**KIRKLEES METROPOLITAN COUNCIL
INVESTMENT & REGENERATION SERVICE**

DELEGATED DECISION TO DETERMINE PLANNING APPLICATIONS

Reference No:	2024/62/91941/W
Site Address:	8, Greystone, Crosland Moor, Huddersfield, HD4 5NF
Description:	Alterations to intergral garage to extend living accommodation
Recommending Officer:	Molly Storer

HOUSEHOLDER DELEGATED REPORT

Proposed Floor Plans

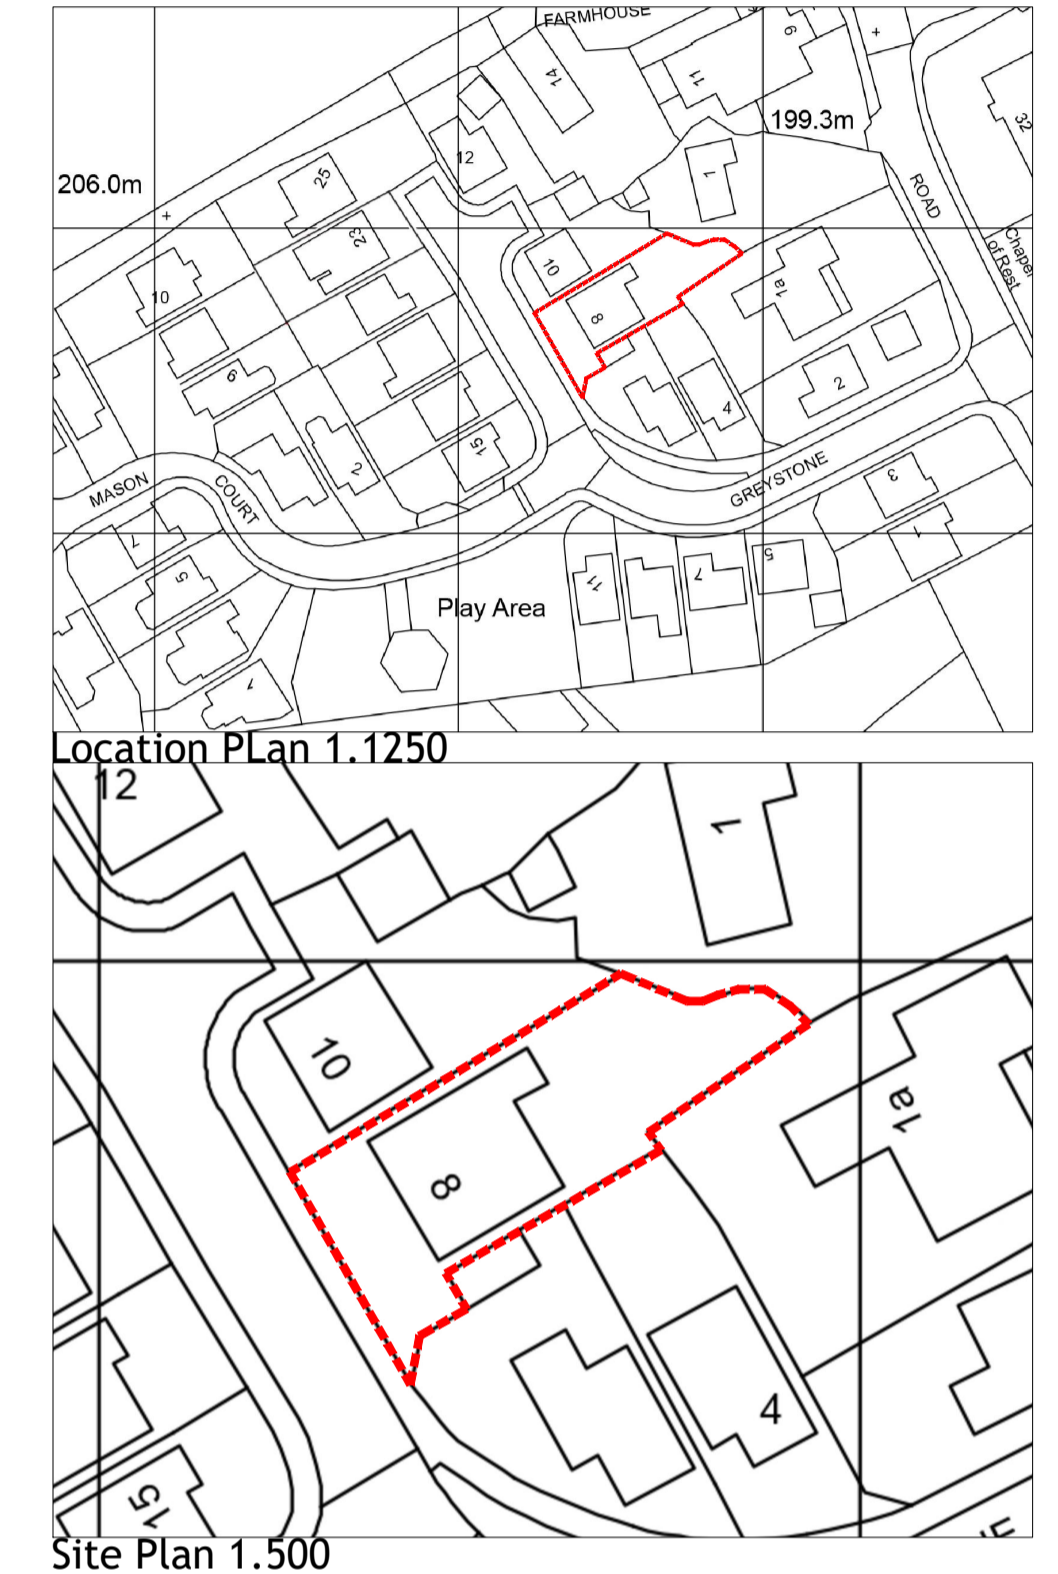
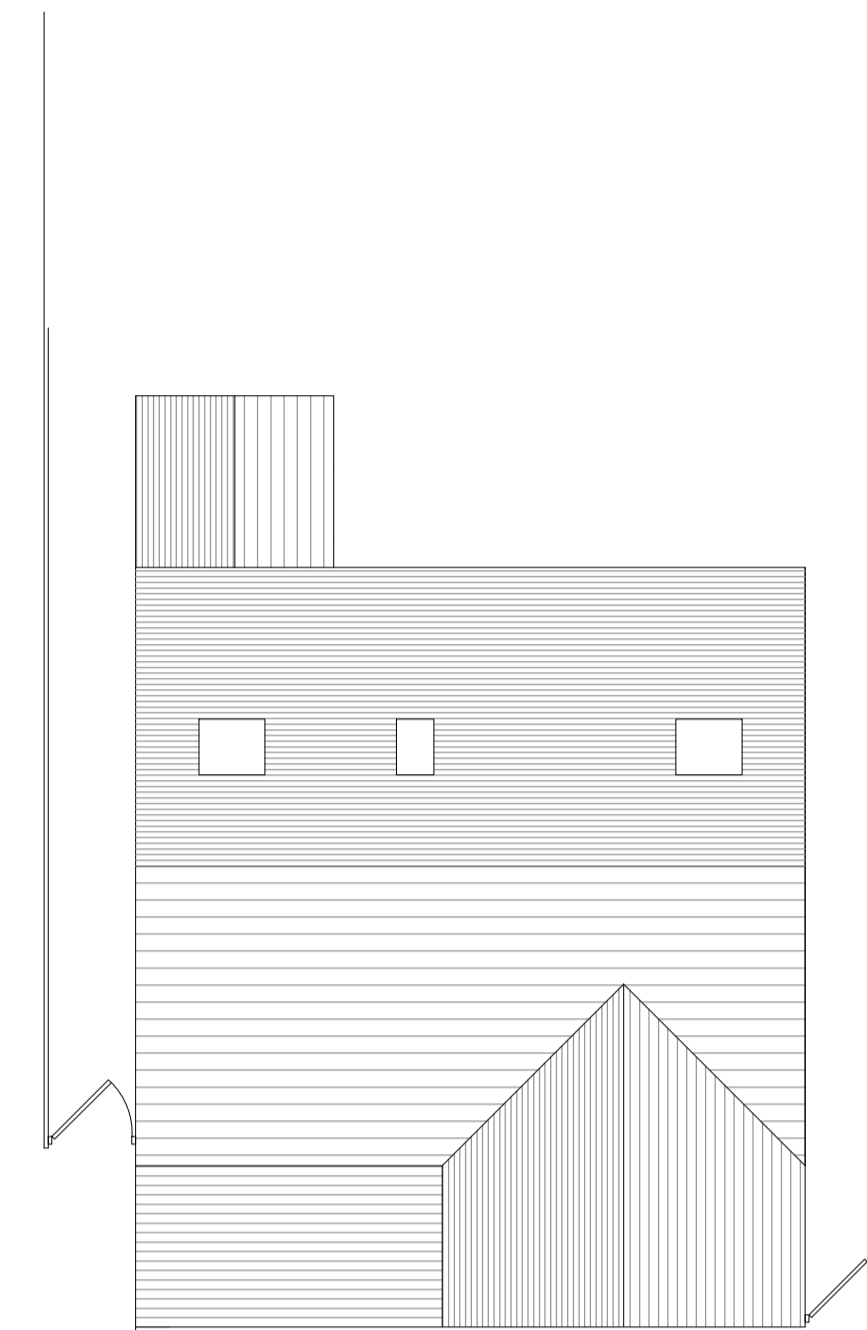
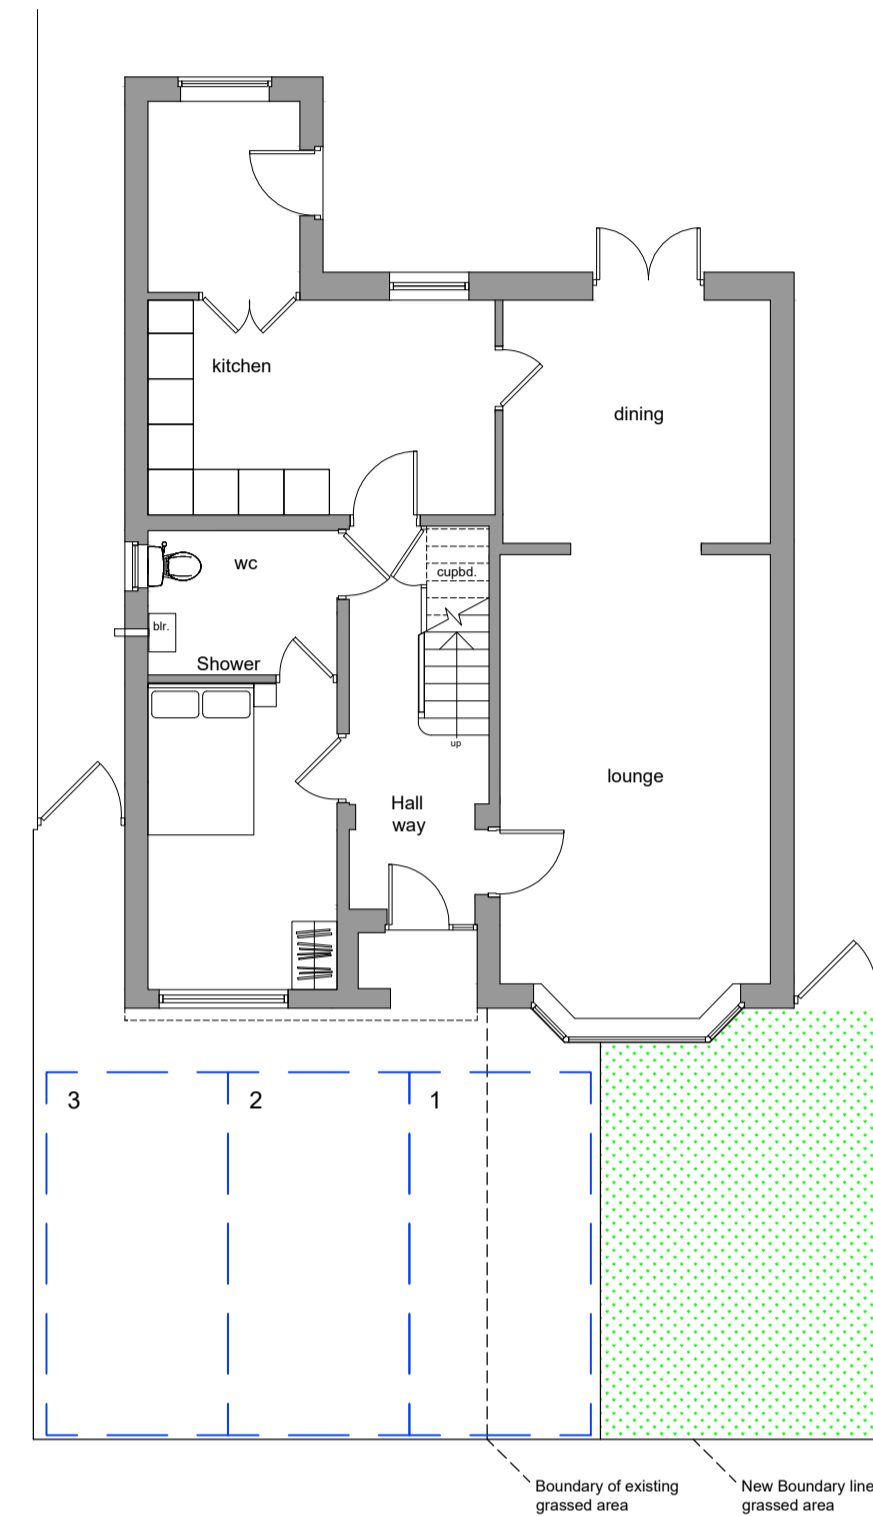
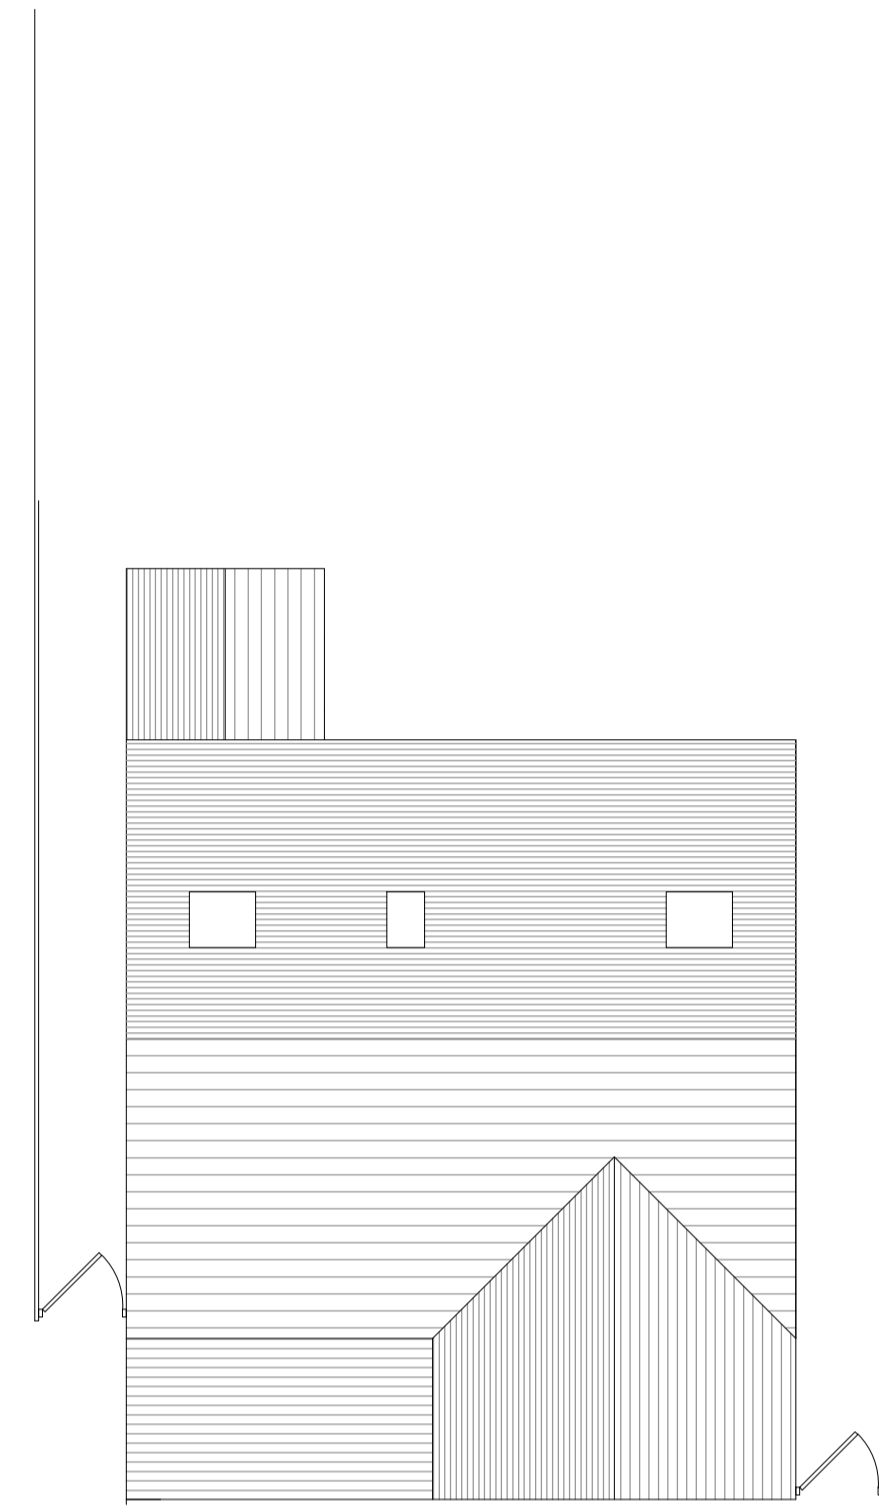
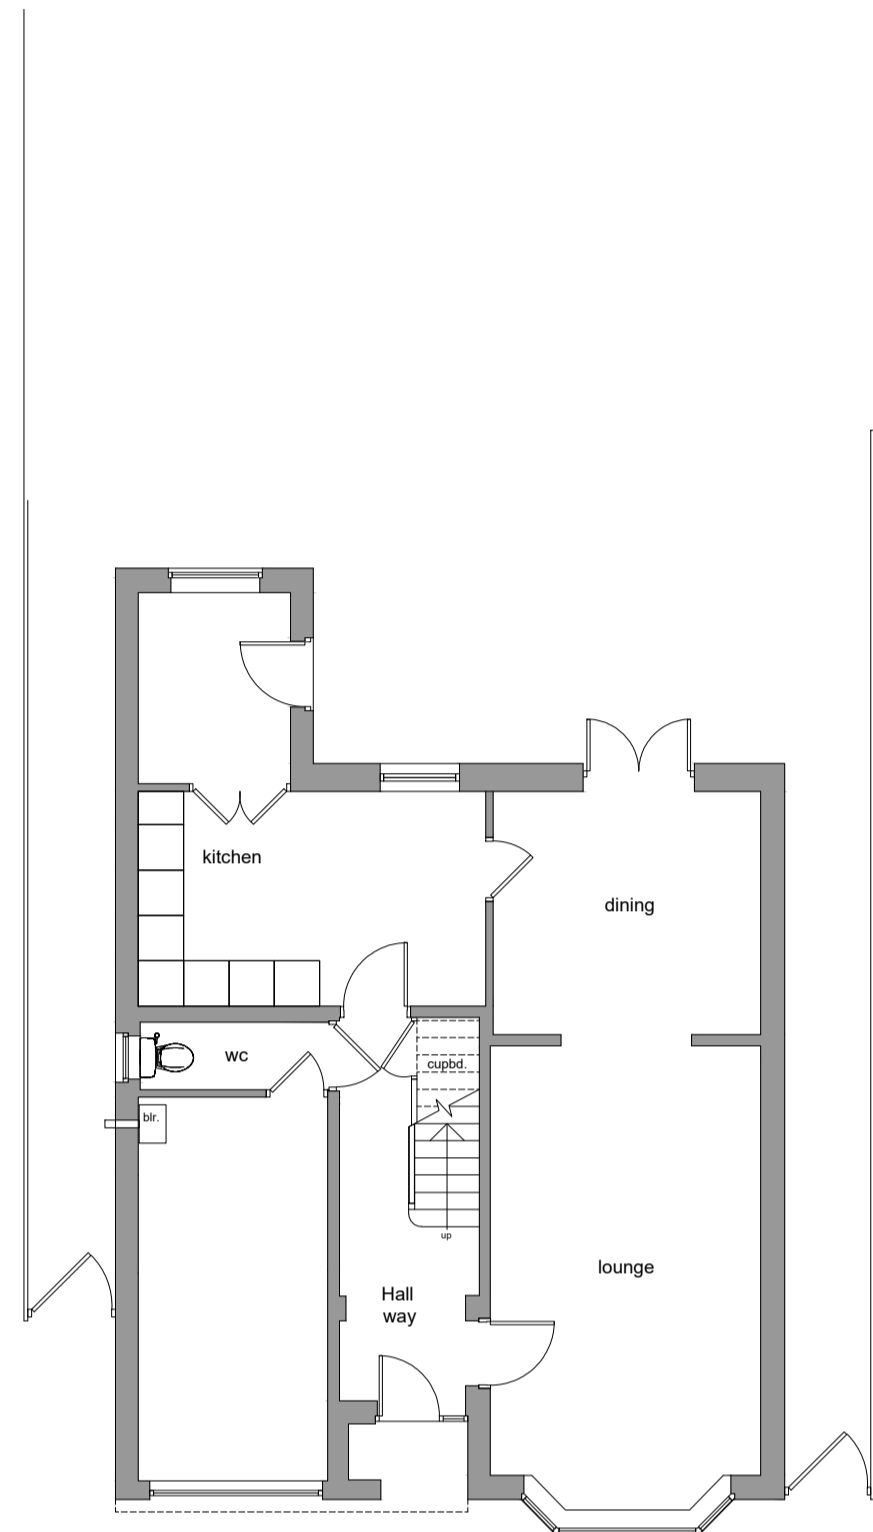
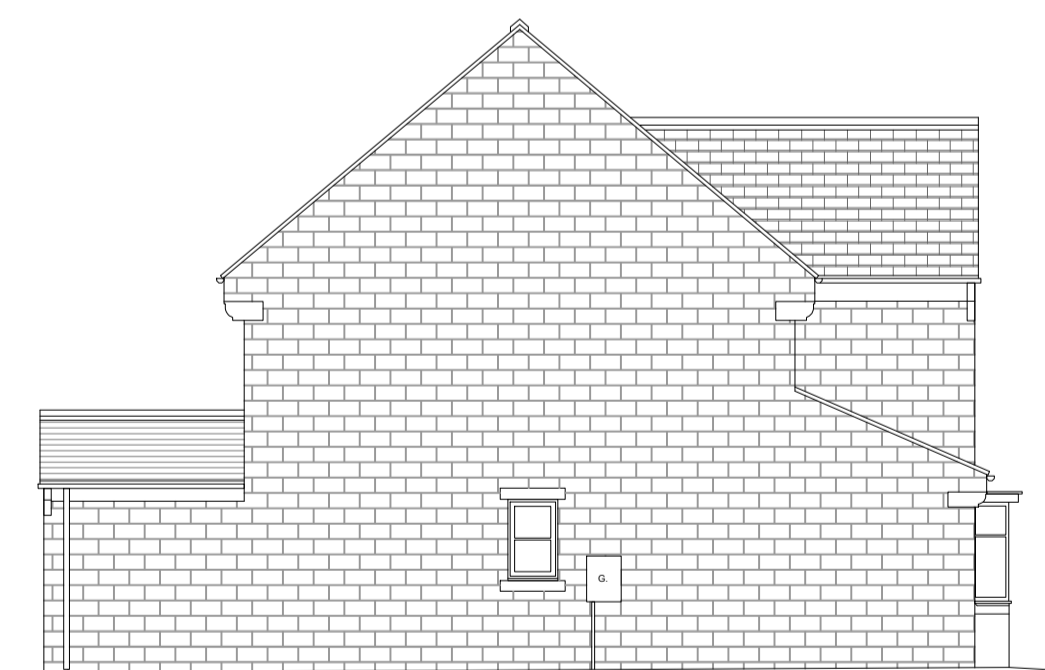
YES / NO	SUMMARY
Negotiations/Amendments during course of application	Yes	Highways requested plans to show how three adequately sized parking spaces will be provided on the site. The agent responded with amended plans to evidence this.
Planning History	Yes	2000/90617 - Erection of 35 detached dwellings and associated garages – Section 106 Reserved matters. Condition 6 on this decision notice states that “The garages shall be used for the garaging of private motor vehicles or for uses ancillary to

Relevant key design principle (KDP) of the SPD, Policy in the Kirklees Local Plan and the NPPF	Further comments	✓ / X / N/A
Impact on highway safety	<ul style="list-style-type: none"> • KDP 15 of the SPD • Policy LP22 Parking (f) of the KLP • Chapter 12 of the NPPF 	N/A	N/A
Parking provision	<ul style="list-style-type: none"> • KDP 15 of the SPD • Policy LP22 Parking (f) of the KLP • Chapter 12 of the NPPF 	<p>Condition 6 of the previous permission requires that garage provision should be retained for vehicular parking only.</p> <p>However, K.C. Highways considered that, on balance, the development is acceptable due to the internal measurements of the garage being 2.5m x 5 metres, which is below the minimum internal dimensions for a garage and substandard for a modern car. Although the number of bedrooms will increase to 6, it is considered that adequate off-road parking would be available at the application property (three spaces retained). This was concluded as a result of amended plans which evidenced that three parking spaces could be provided to the front of the existing property with some removal of landscaping.</p>	✓

Plan Type	Reference	Version	Date Received
Amended proposed plans showing location of parking spaces	2427/01	A	29/08/2024
Application form	-	-	10/07/2024

Proposed Elevations

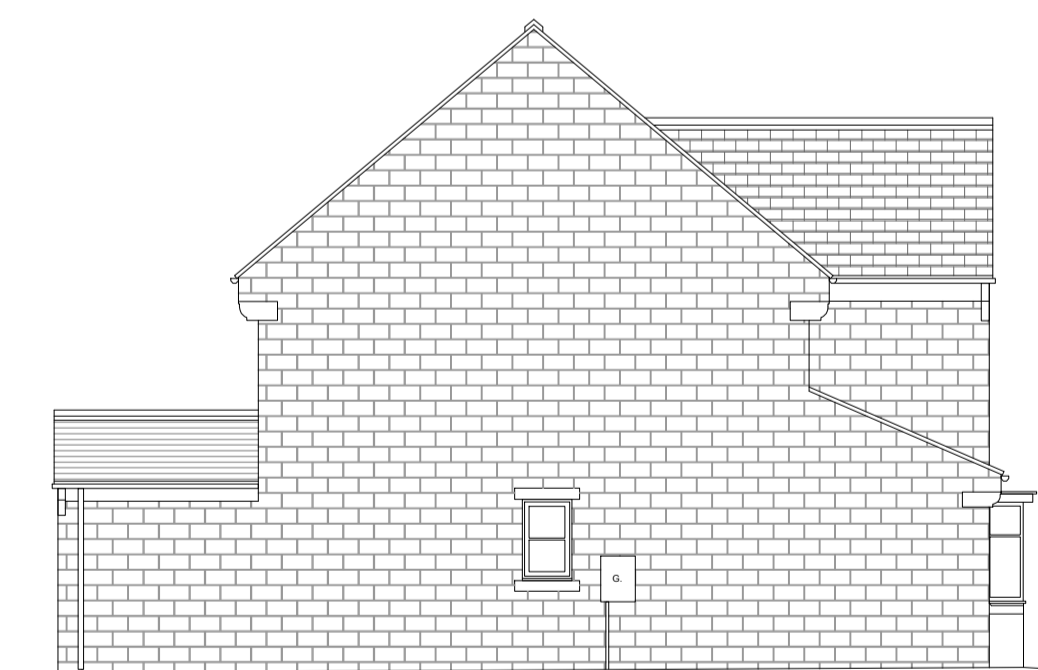
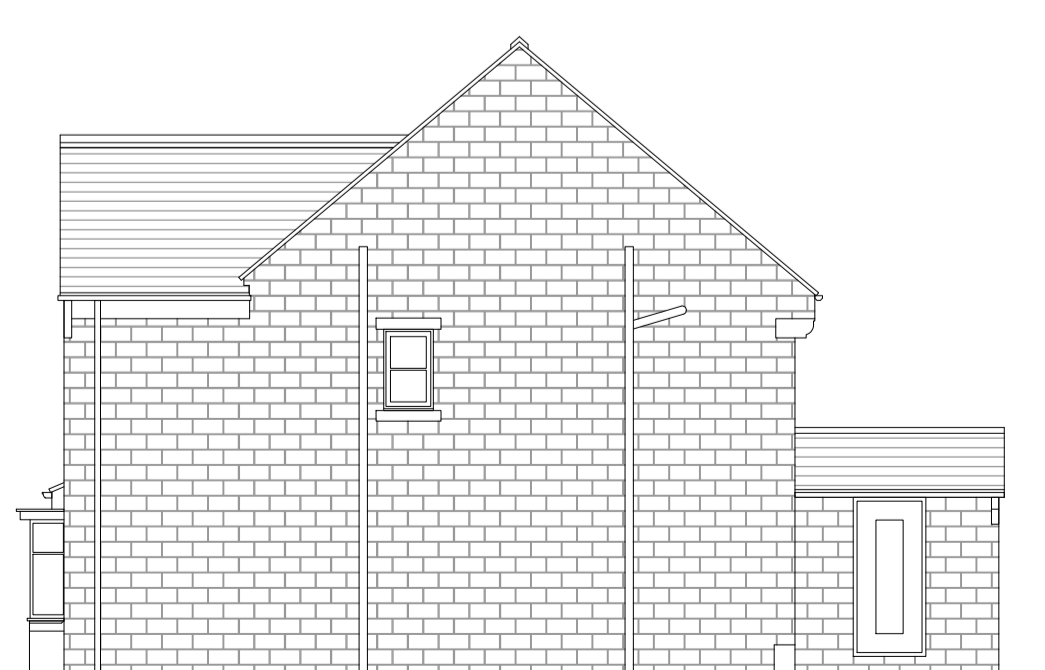
The alterations to convert the garage to living accommodation would not increase the existing structure or footprint of the existing dwelling. The only external alterations would be the removal of the garage door to the front elevation and the installation of one window.

Window proportions	<ul style="list-style-type: none"> • KDP 1 and 2 of the SPD • Policy LP24 Design (a), (c) and (d) of the KLP • Chapter 12 of the NPPF 	Window for garage conversion would match that on the first floor and therefore would not appear out of place.	✓
Accessibility for all users	<ul style="list-style-type: none"> • KDP 17 of the SPD • Policy LP24 Design (f) • Chapter 12 of the NPPF 	Access to the property would remain the same.
